DR: P22180

21 March 2017

PROPOSED BERYL SOLAR FARM – 276 PERSEVERANCE LANE, GULGONG

Figure 1-3 Proposed boundary realignment (maps provided by First Solar (Australia) Pty Ltd)

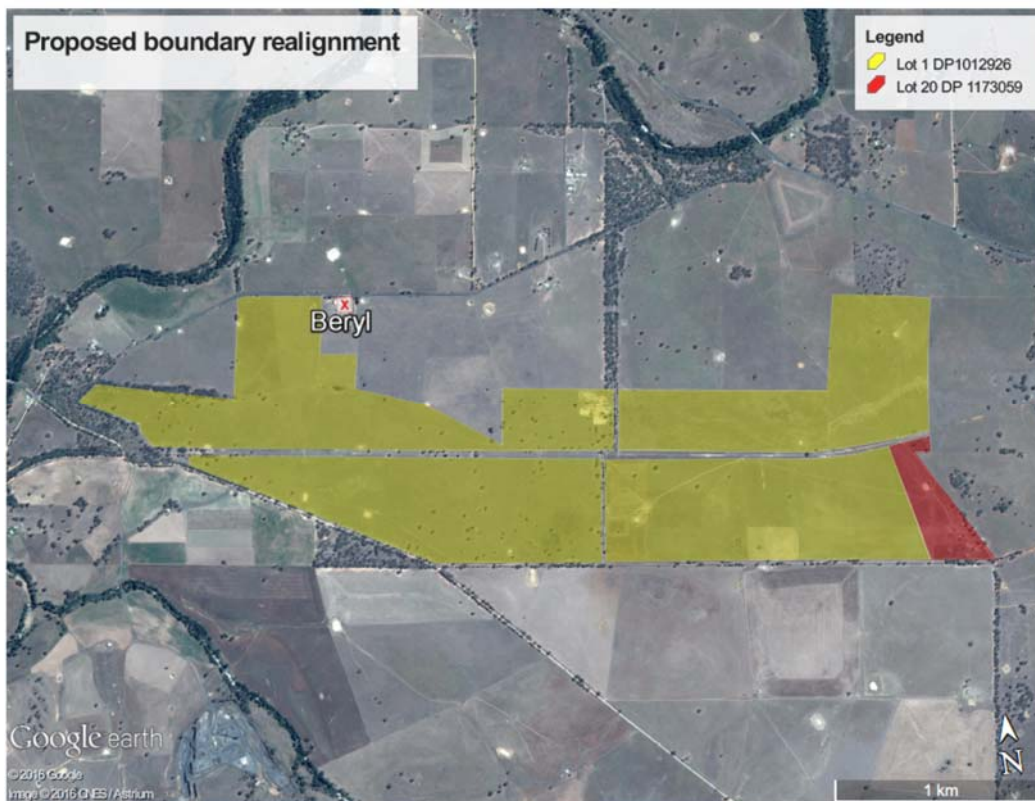
Council raises no objection to the proposed subdivision, even though it is not compliant with Council's LEP. The proposal will not result in any additional dwelling entitlements for the site and will essentially relocate the existing smaller Lot 1 to encompass the existing dwelling that sits upon the larger Lot 20.

It is requested that the direct access arrangements to Perseverance Lane for the dwelling be retained and that the location of the new lot boundaries ensure that all ancillary structures and septic systems in association with the dwelling are retained within the same lot with adequate setbacks.
